Kirklees Council
Planning and Development Service
PO Box 1720
Huddersfield
HD1 9EL

Date: 29-Mar-2023
Our Ref: 2022/92621

**Discharge conditions 3 (materials), 5 (Phase 1 Desk Study Report), 6, 7 (Phase II Intrusive Site Investigation Report) 11 (noise), 12 (boundary treatments) on previous permission 2022/90223 for variation condition 2 (plans and specifications) on previous permission 2021/92116 for erection of detached dwelling and single and two storey rear extension to existing dwelling
23, Fall Lane, Hartshead, Liversedge, WF15 8AP
Application Number: 2022/92621**

PROPOSED BOUNDARY TREATMENT PLAN

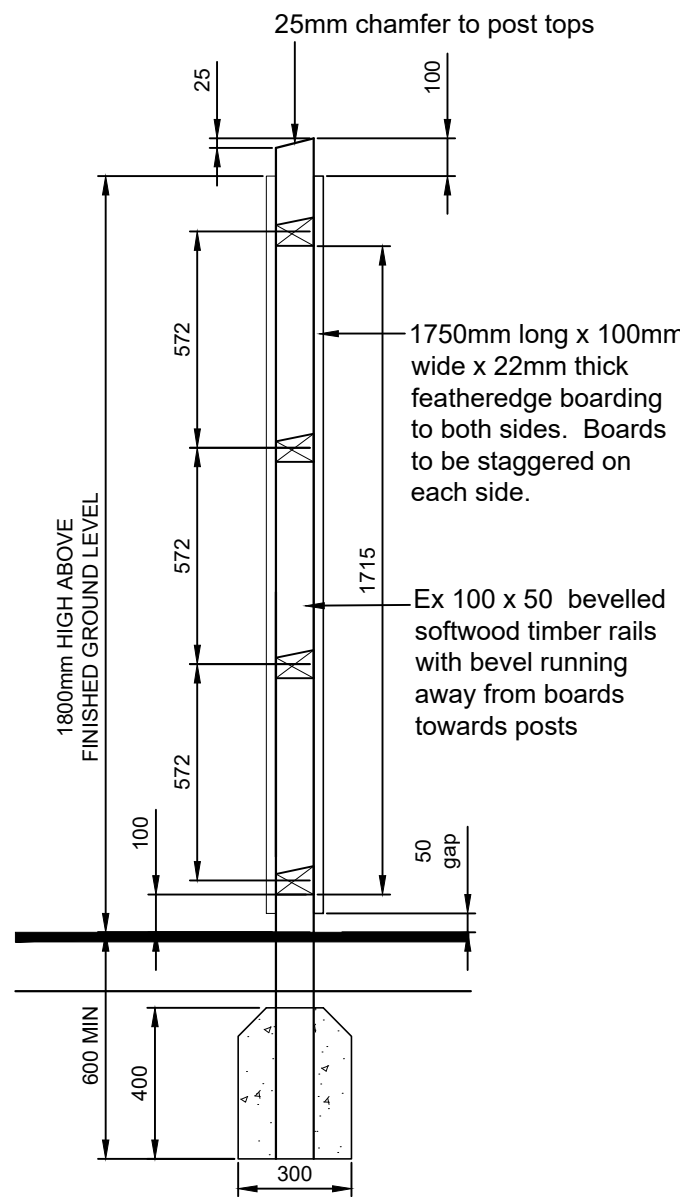
- Plan ref 2691 (100)08 titled 'Boundary Treatment'.

The proposed development will retain the existing walling and fence that fronts on to the highways. All new fences and boundary treatments are within the site and not set fronting on to the highway. All of the boundary treatments proposed are 1.8m or less. The final development would see a combination of existing and proposed fencing, hedgerow, timber gates and rendered retaining wall to bound the site. The proposed boundary treatments would accord with policy set out in the condition in respect to visual amenity and create a high quality finish when complete. As such, condition 12 can be considered discharged for the purpose of the pre-commencement condition, however, the development must now be completed in accordance with the approved details before the dwellings are first brought into use and thereafter retained.
